CITY OF PORTLAND, MAINE
 DEVELOPMENT REVIEW APPLICATION
 PLANNING DEPARTMENT PROCESSING FORM
 DRC Copy

Single Family Home 40'x 28'

RE: Application for Single Family House, Farragut Street, ID # 2005-0139

Upon review of the site plan, the City's Planning Division has the following comments:

SKETCH PLAN
 84 FARRAGUT STREET PORTLAND, MAINE

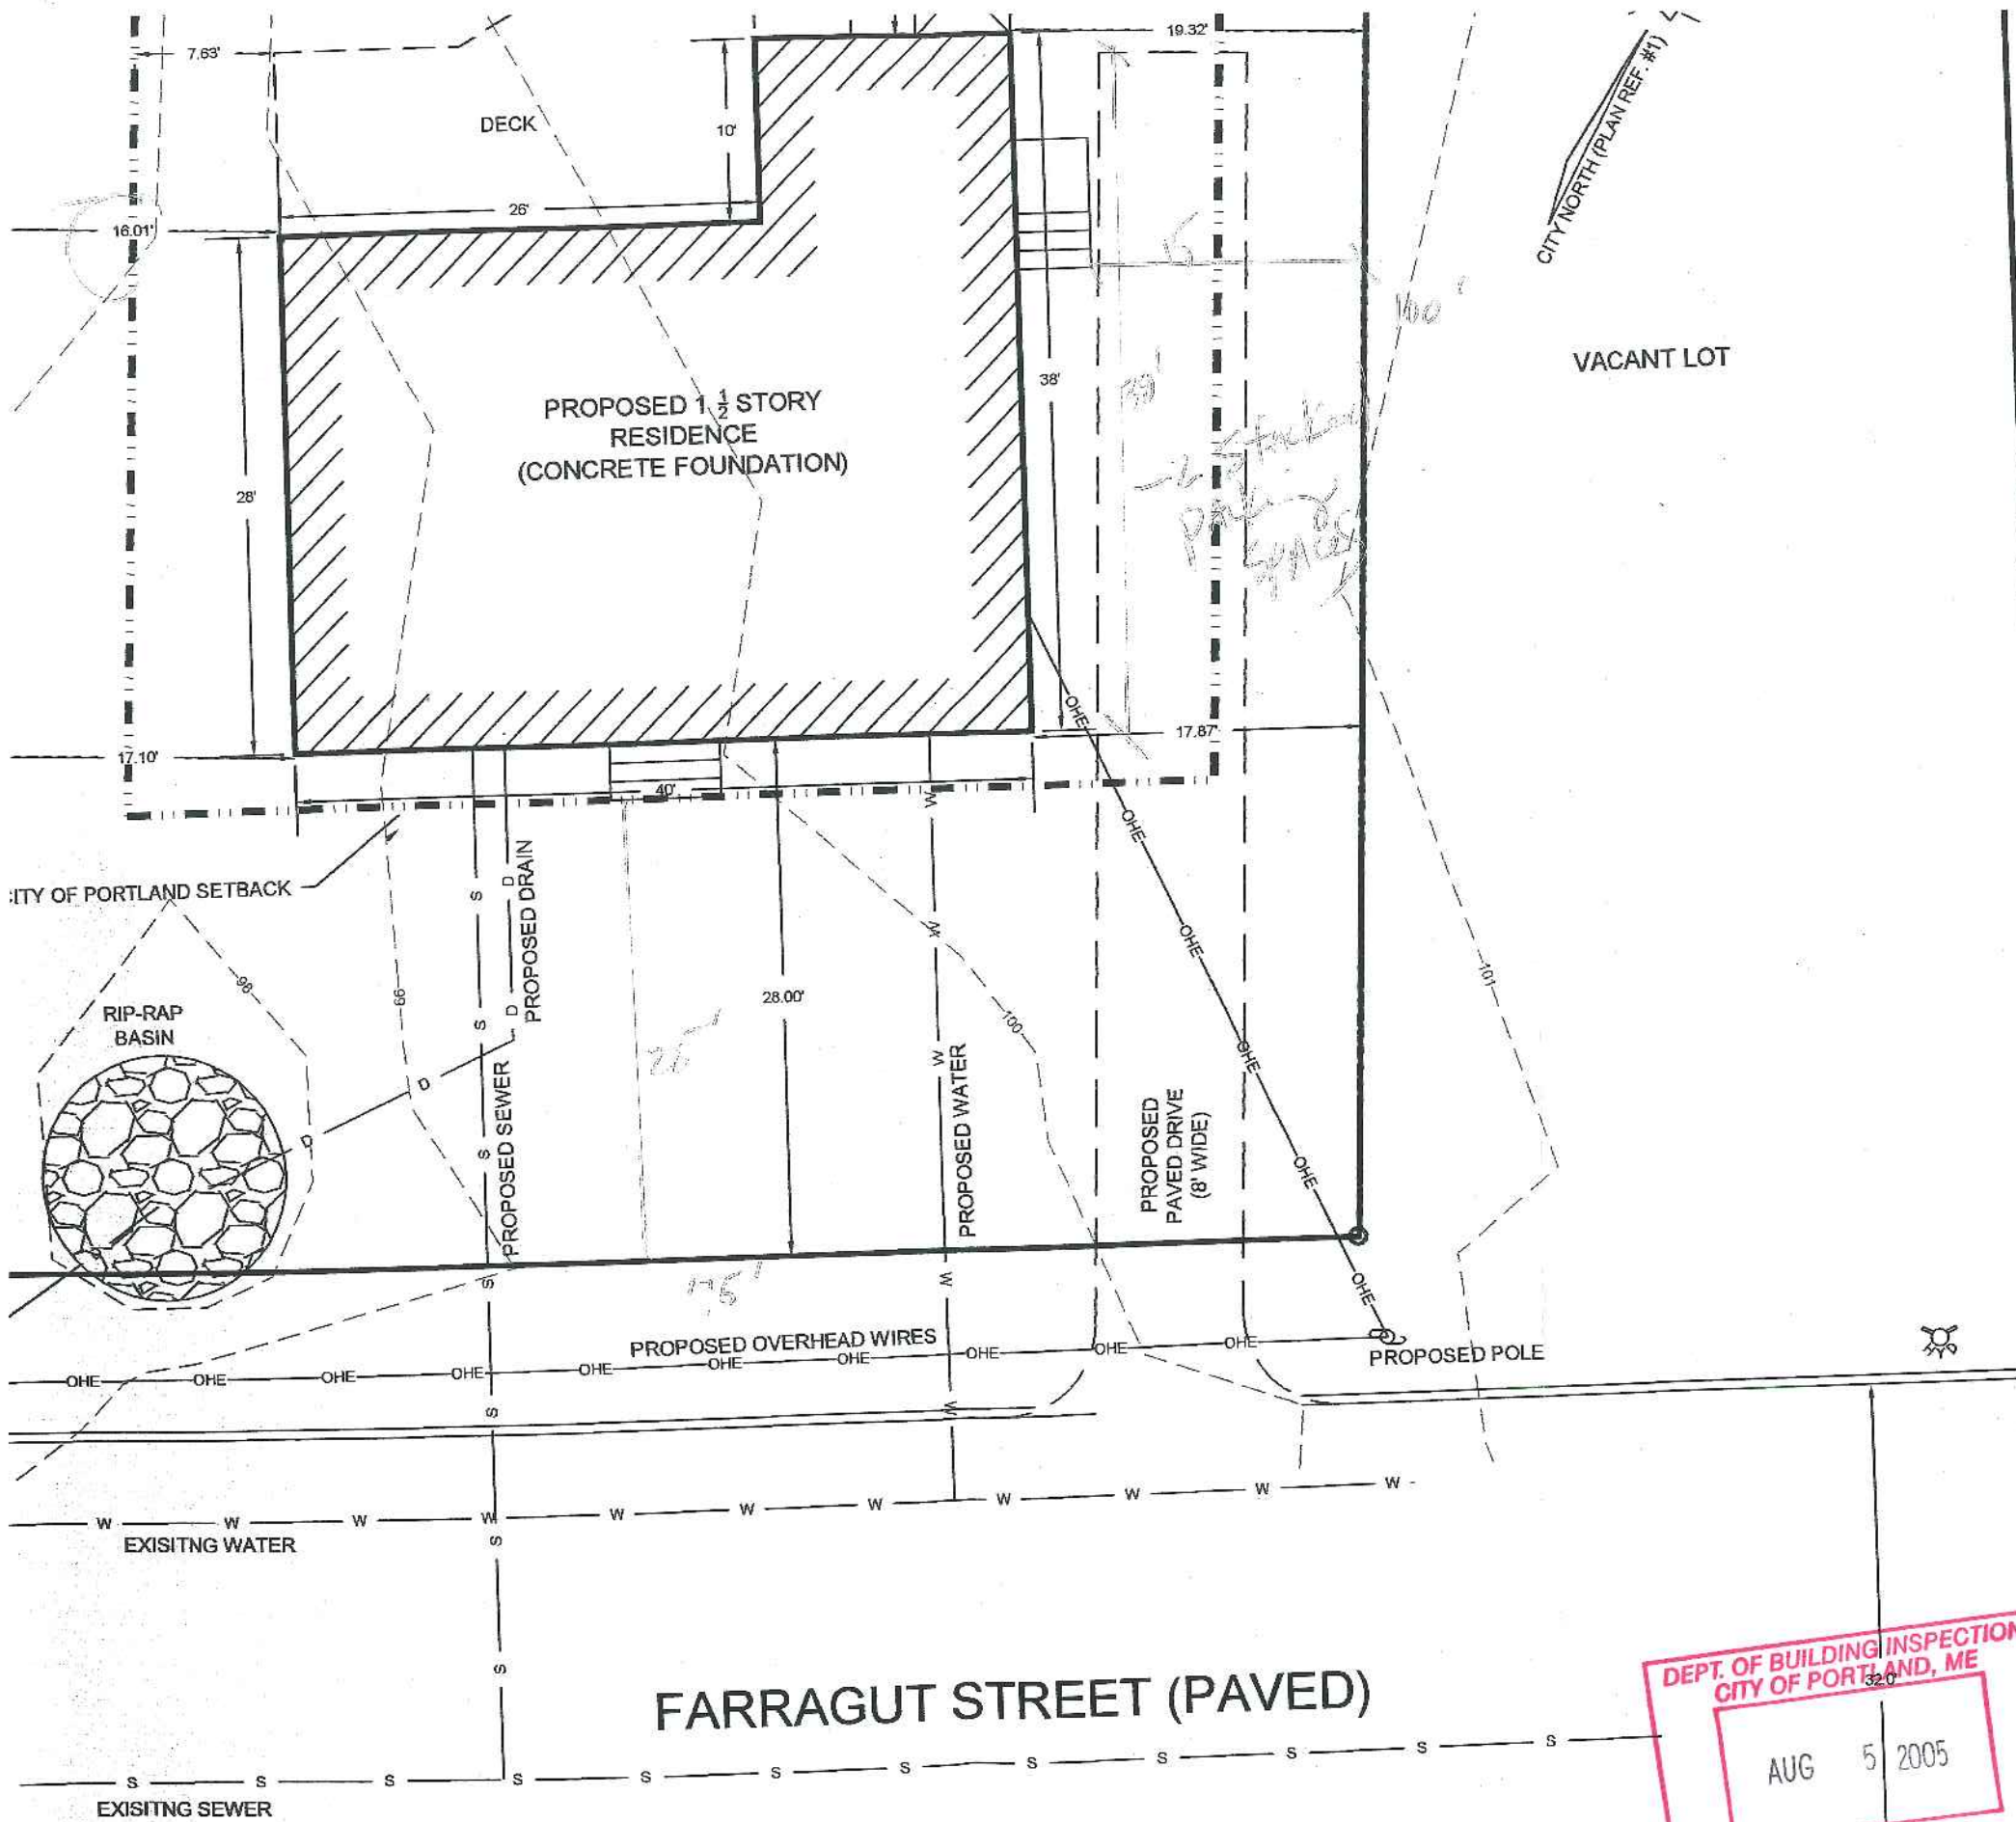
1. Please provide proposed grading/topography on the lot. This should match the previously approved grading as shown on the Farragut Street Extension plans approved on April 16, 2003. Add to plan.
2. Please note the Finish floor elevation. This should be tied into the same elevation data as your proposed topography.
3. Add the distances of the lot lines to the site plan.
4. Two street trees are required for single-family development, along your street frontage. Add to plan.
5. A backflow preventer is highly recommended on the 4" storm drain lead. Please add a note to the plan.

#80 FARRAGUT STREET

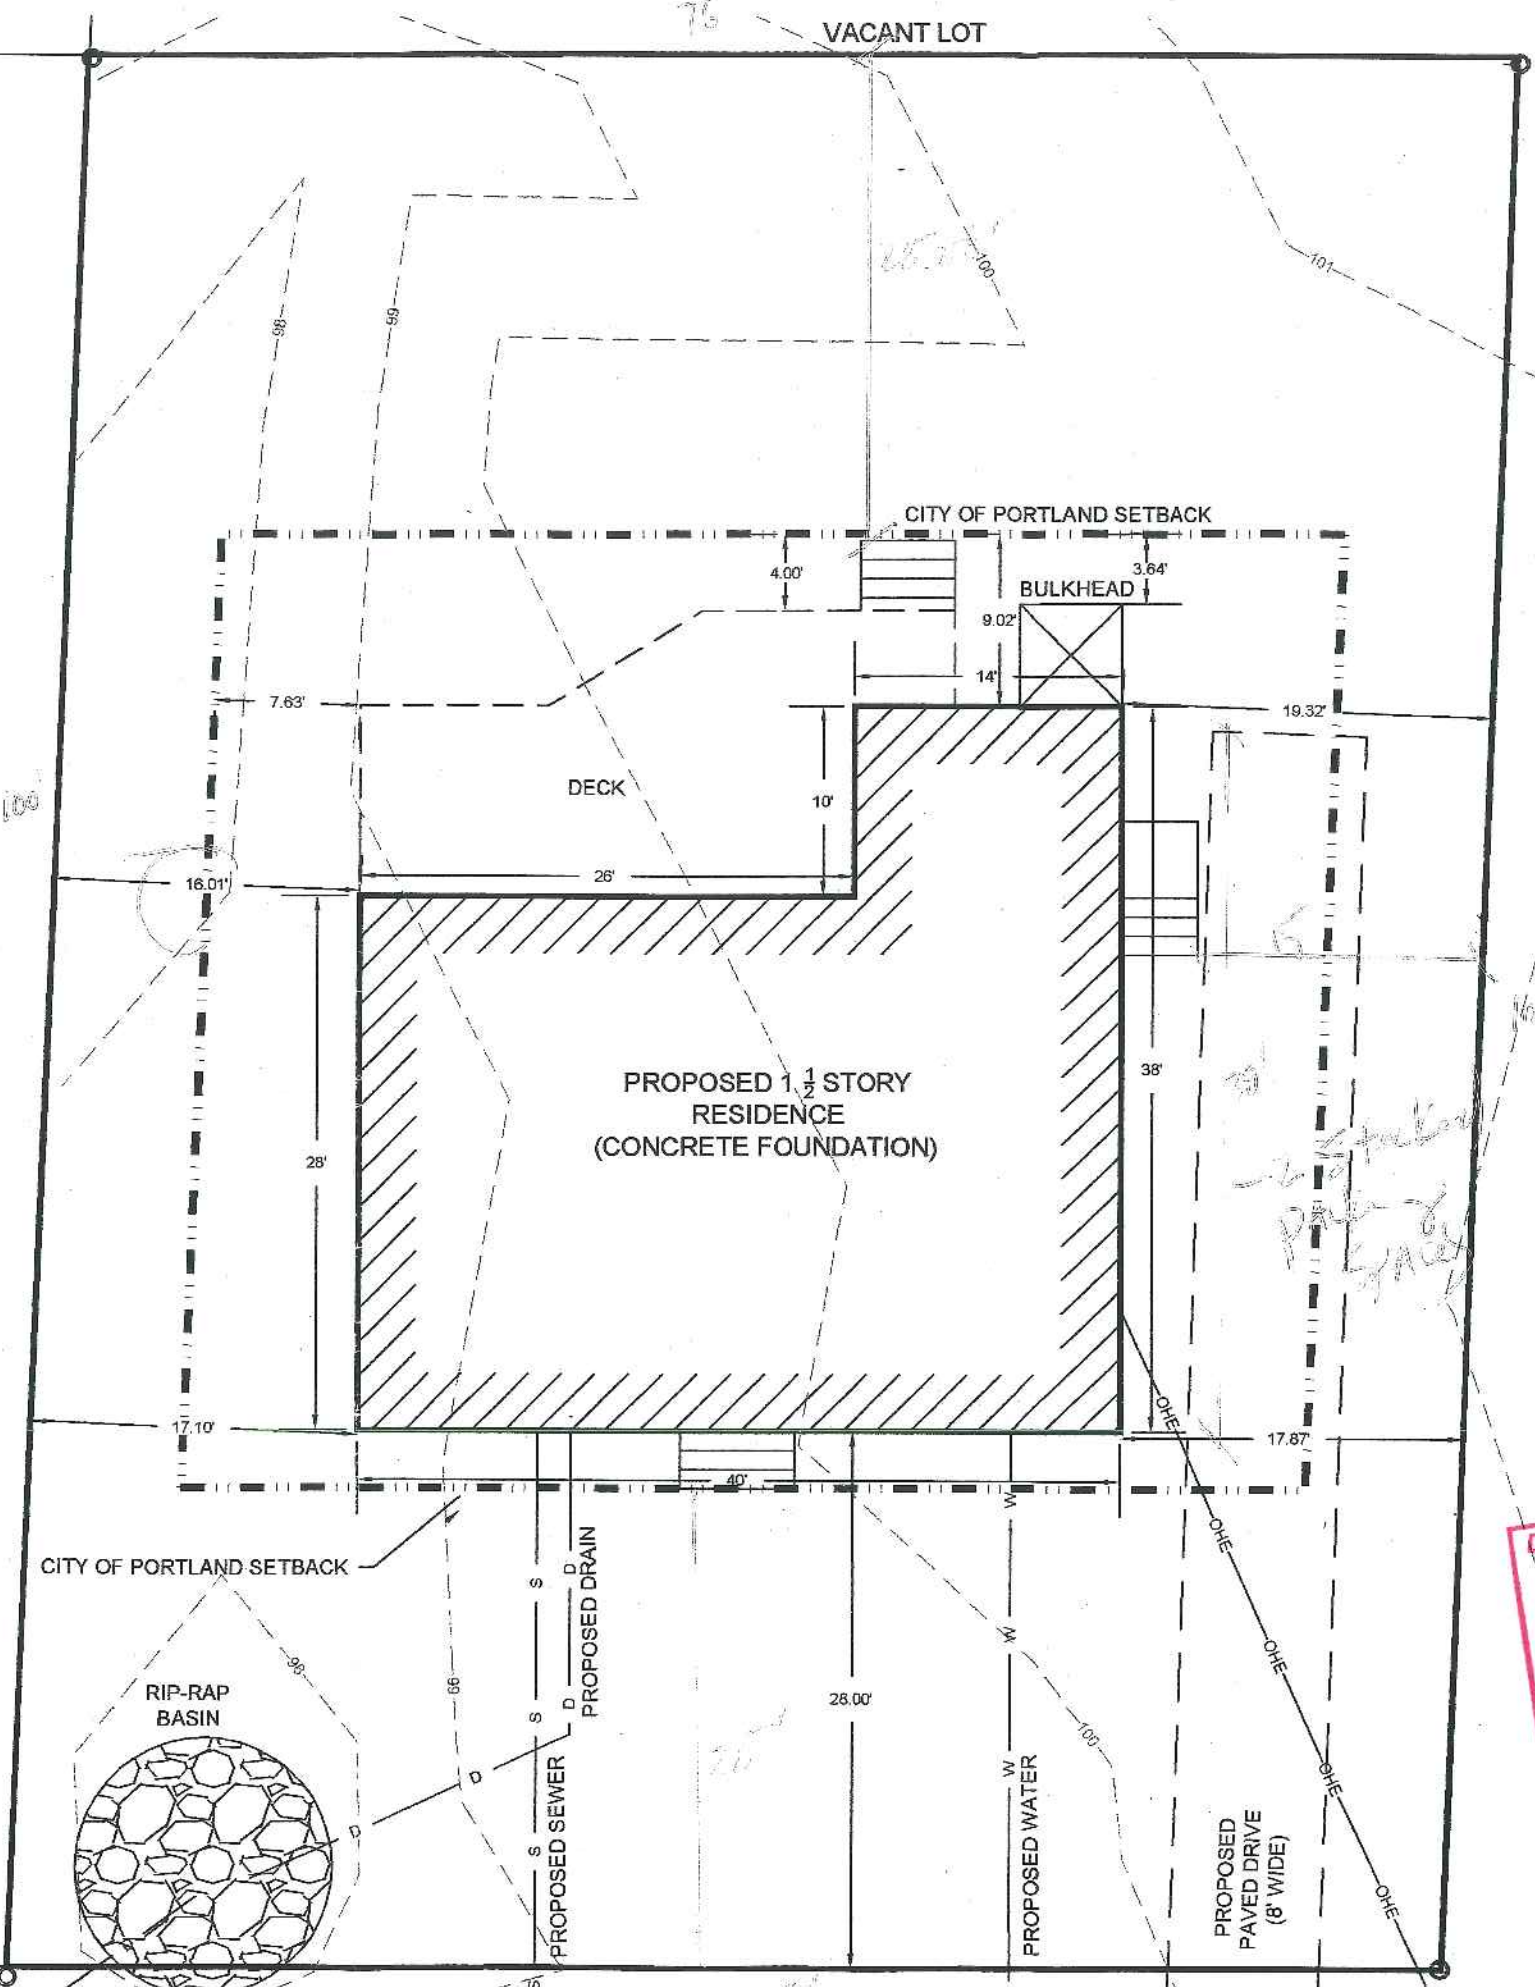
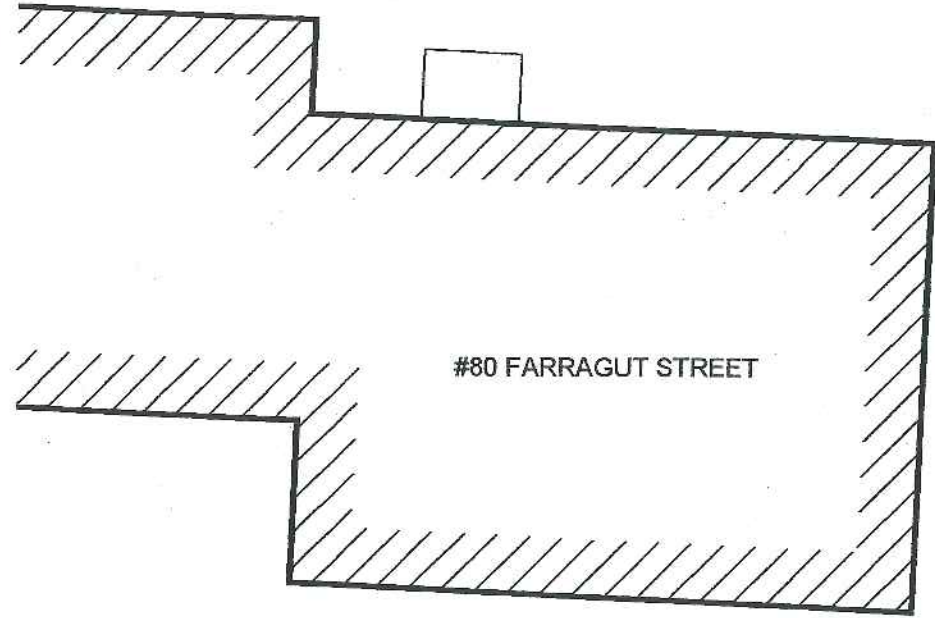
*8-5
 Revised Plans
 Do Not Address
 Any Comments*
